OXFORDSHIRE COUNTY COUNCIL'S RESPONSE TO CONSULTATION ON THE FOLLOWING DEVELOPMENT PROPOSAL

Application no: 21/01630/OUT

Proposal: Outline planning application for residential development (within Use Class C3), open space provision, access, drainage and all associated works and operations including but not limited to demolition, earthworks, and engineering operations, with the details of appearance, landscaping, layout and scale reserved for later determination

Date: 14 July 2021

**4600-1100-T-020**

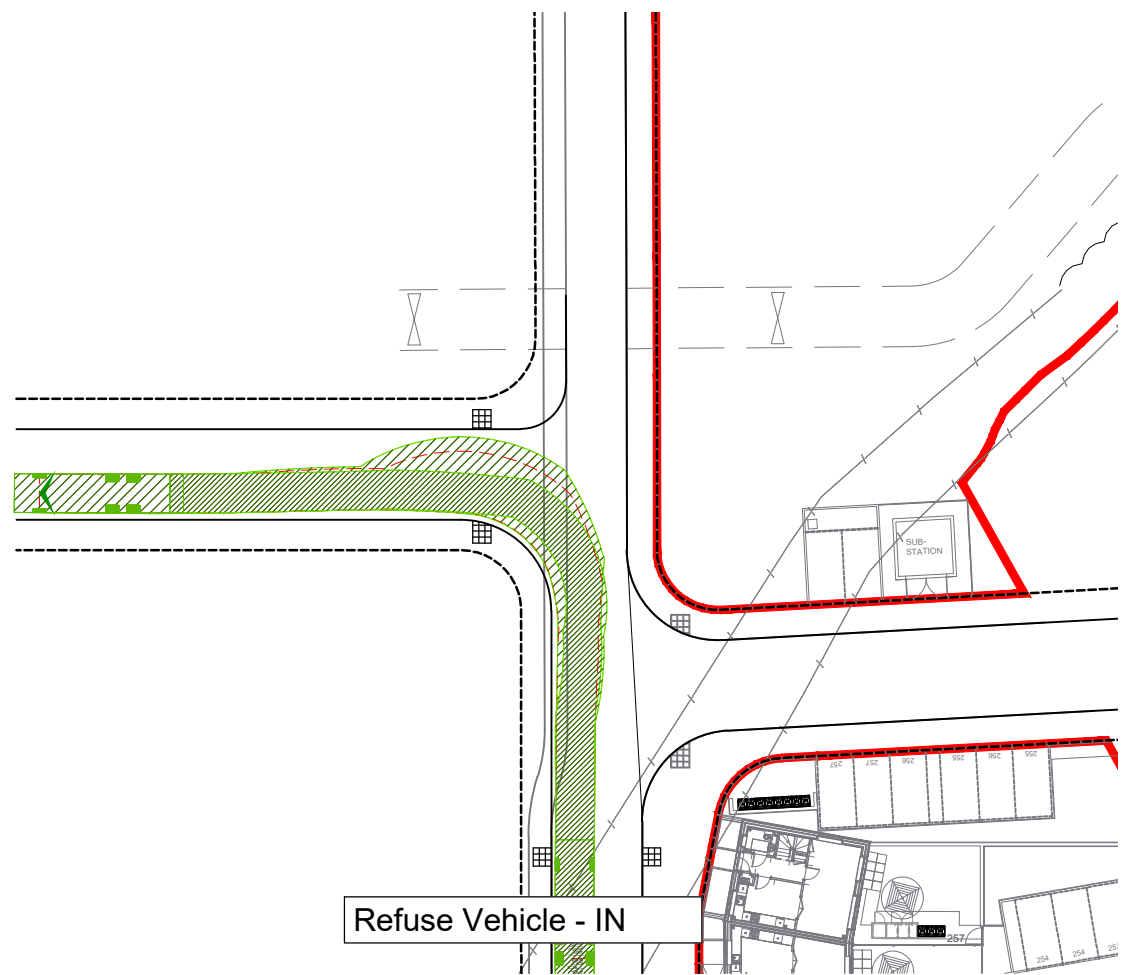
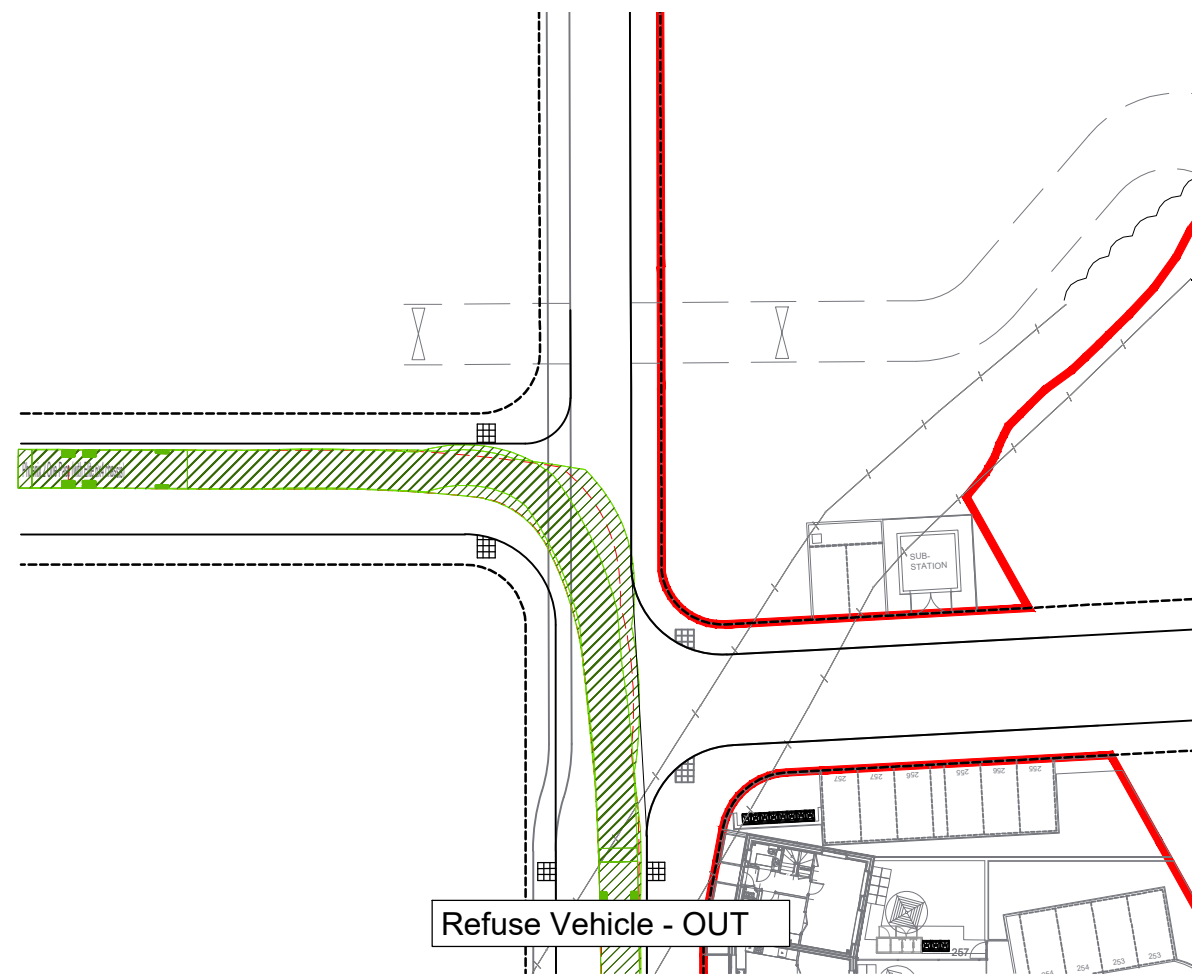
With regard to the layout, the vehicle swept path analysis is incomplete - no SPA has been provided for Access A, nor has the right turn out for Access B, and the right turn in for Access C been provided. Access B shows that the refuse vehicle entering the site would need to cross well over into the path of opposing vehicles on the spine road and

take up nearly all of the width of the access. This is likely to cause conflict with vehicles and cyclists exiting Access B to turn right, and the risk that vehicles may need to reverse, causing a safety risk.

REVISION DETAILS		
DRAWING NO.		
<b>4600-1100-T-021</b>		
DRAWN	APPROVED	DATE
GSF	MK	SEP 21
SCALE		REV
1:500@ A3		B

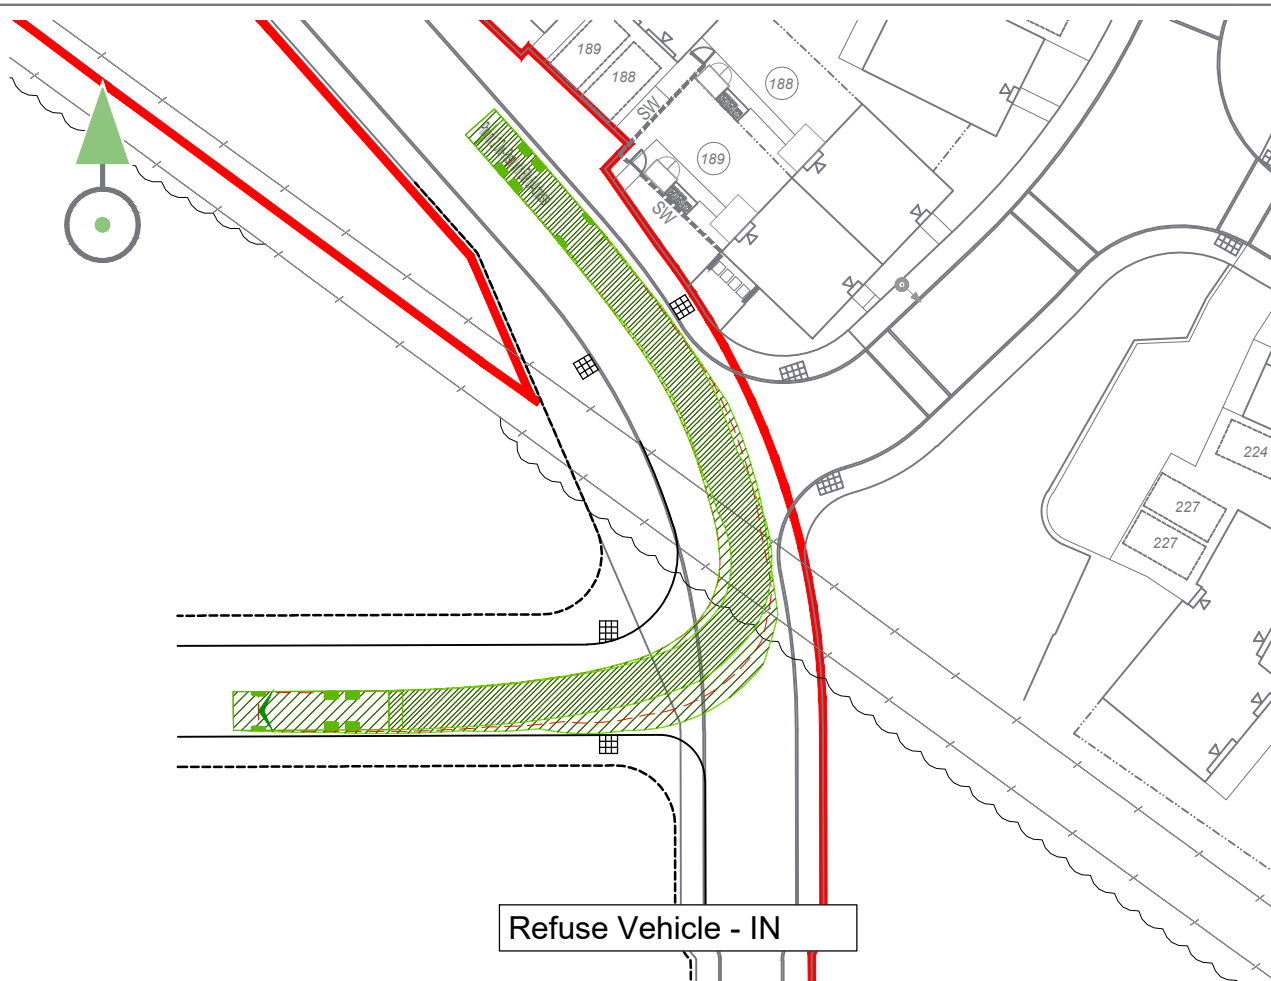
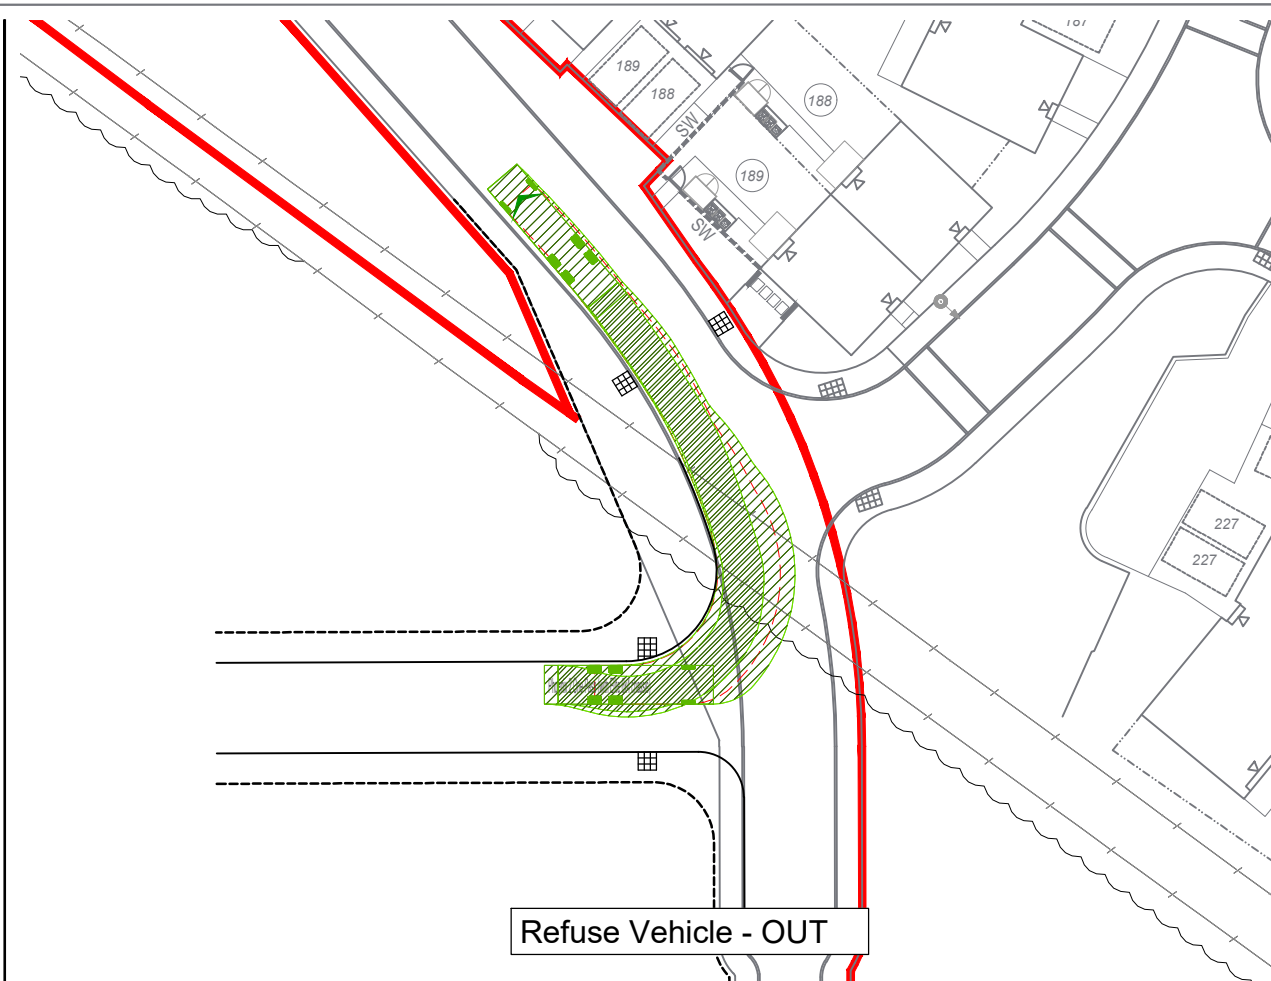
At access C, the exiting refuse vehicle would take up nearly all the carriageway of the spine road, with risk of conflict particularly for cyclists, who would be on carriageway at this point. **Further information is required, to provide the missing SPA, plus revised geometry or demonstration of sufficient forward visibility to avoid conflicts, and in particular the need for vehicles to reverse, or cyclists to have to get onto the footway.**

Construction Access  
(Western Parcel)

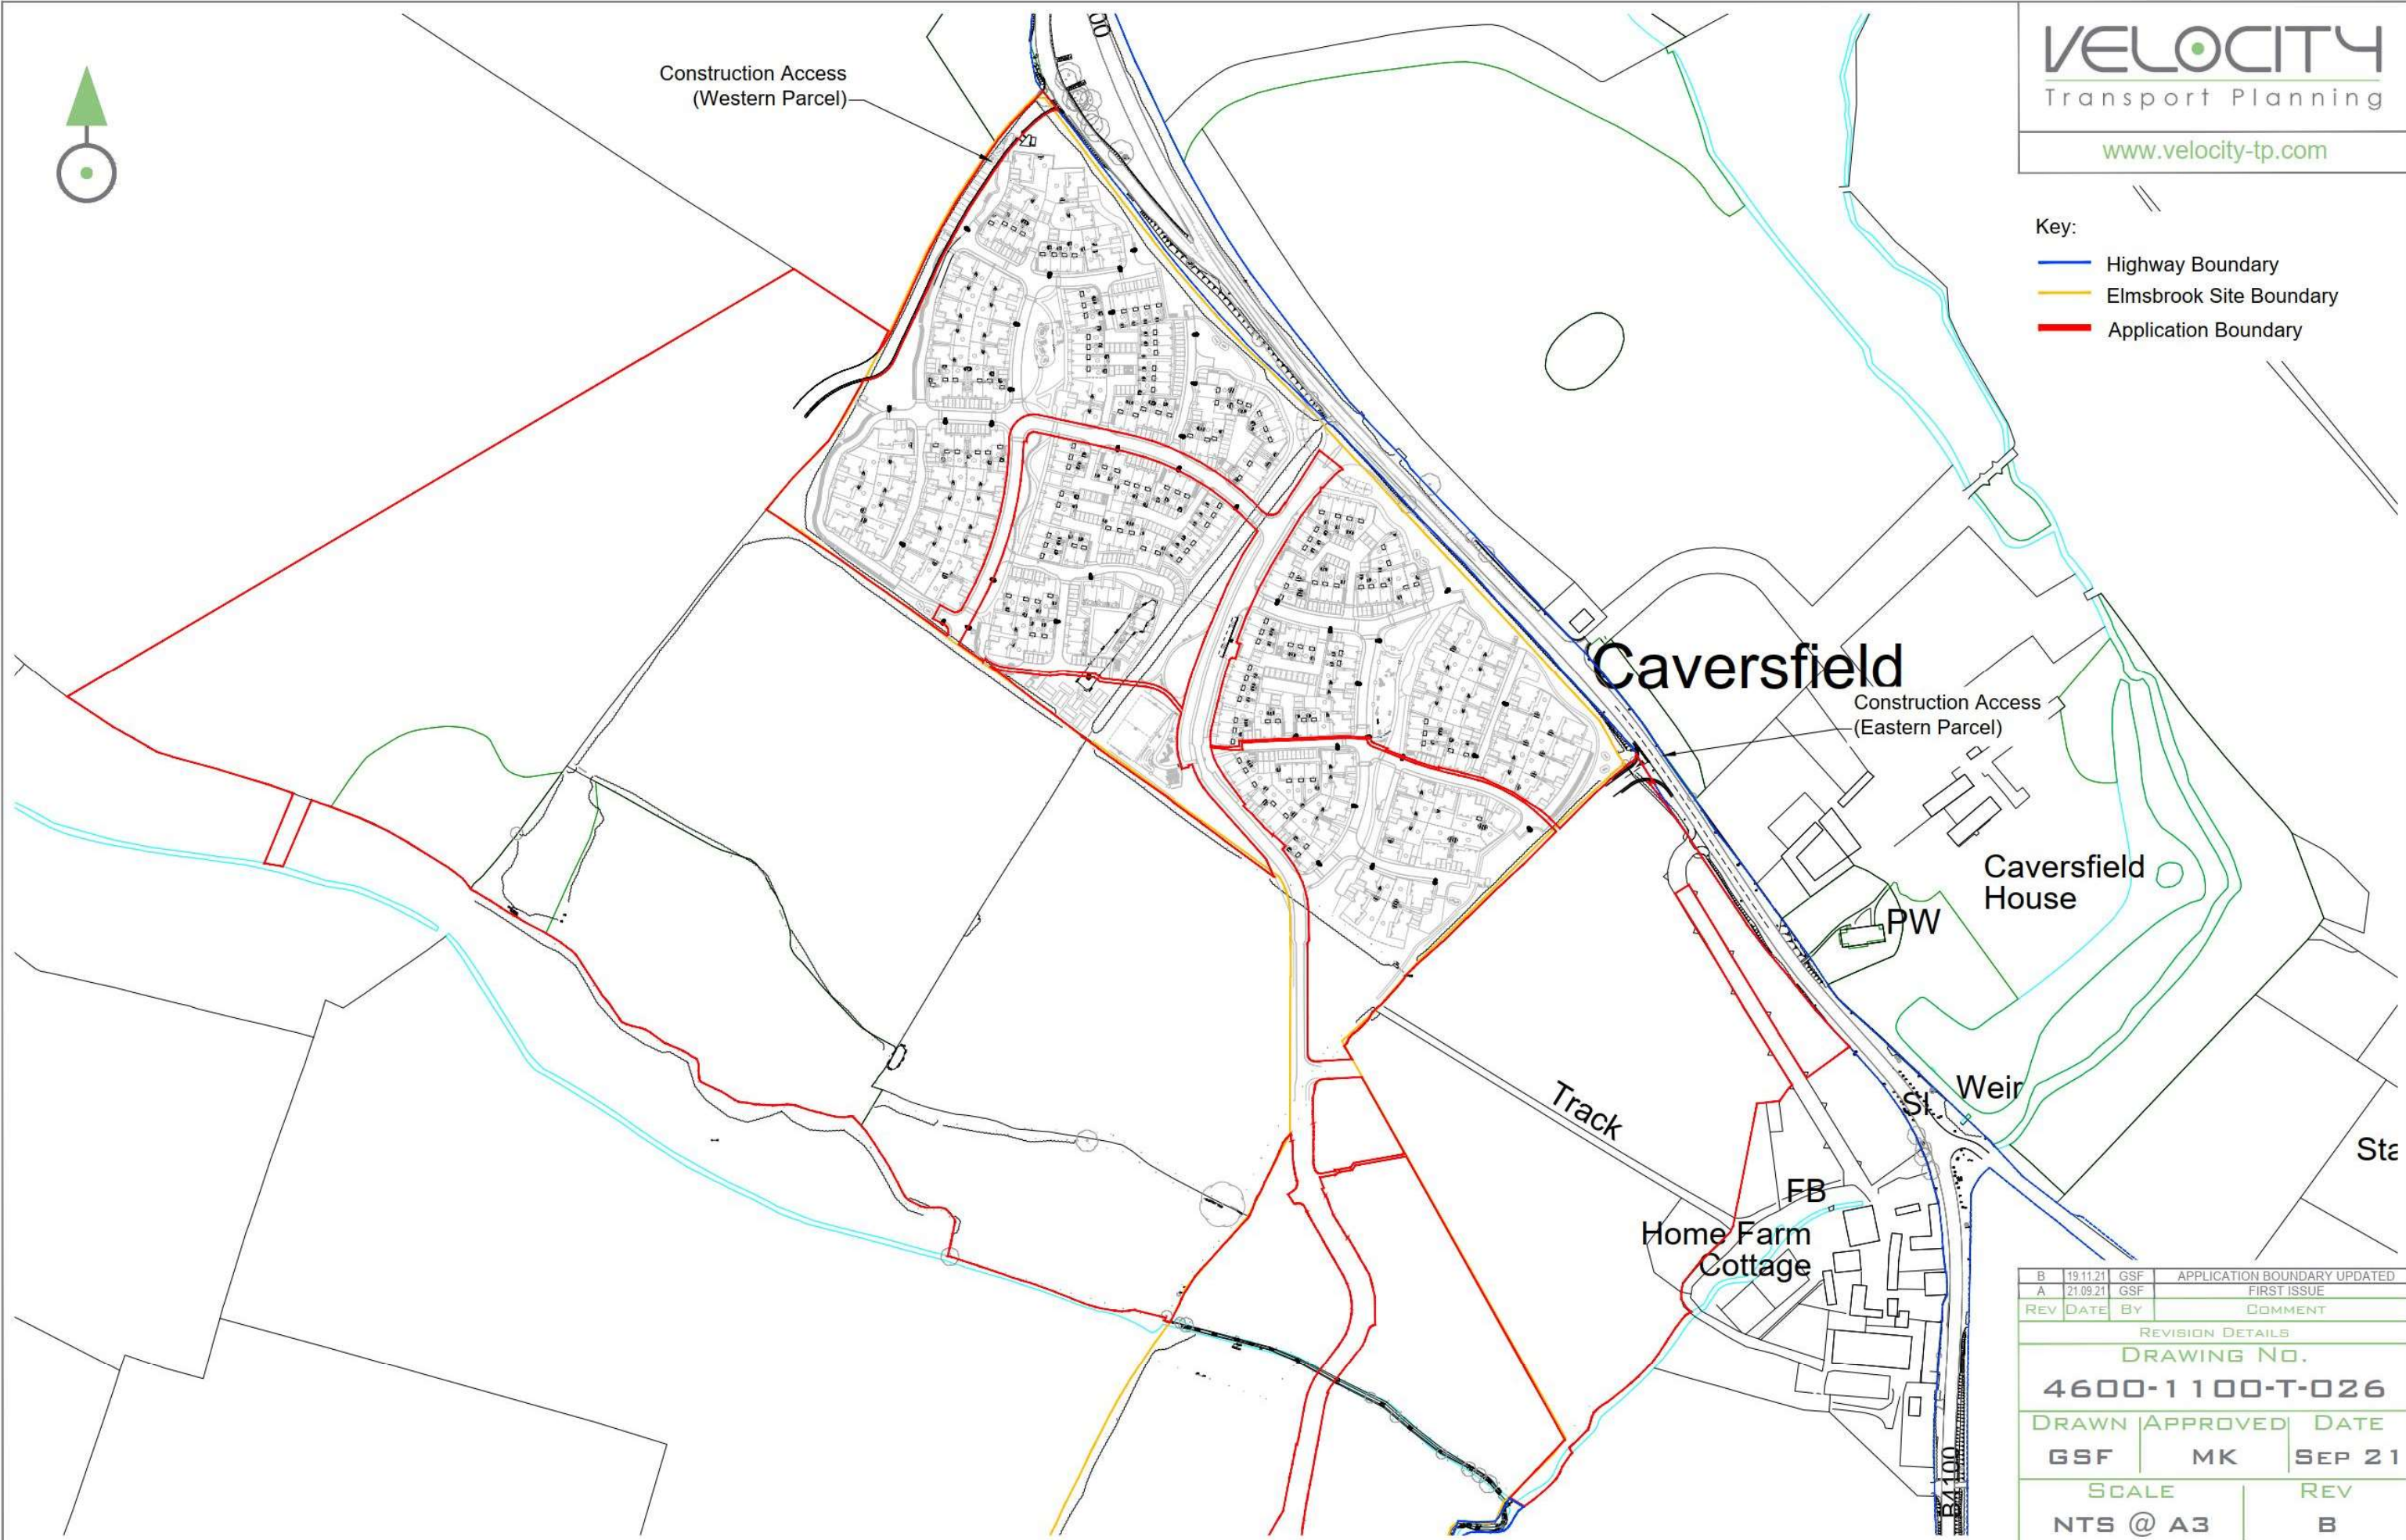
It is assumed that construction access into the western parcel would be off the spine road. Access B would not be acceptable as vehicles would have to pass the school and village centre. Access C has awkward geometry and we would need to see swept path analysis for a maximum size artic, which I do not think would be achievable. Access D would not be appropriate as it passes through residential streets. **Further information is required.**
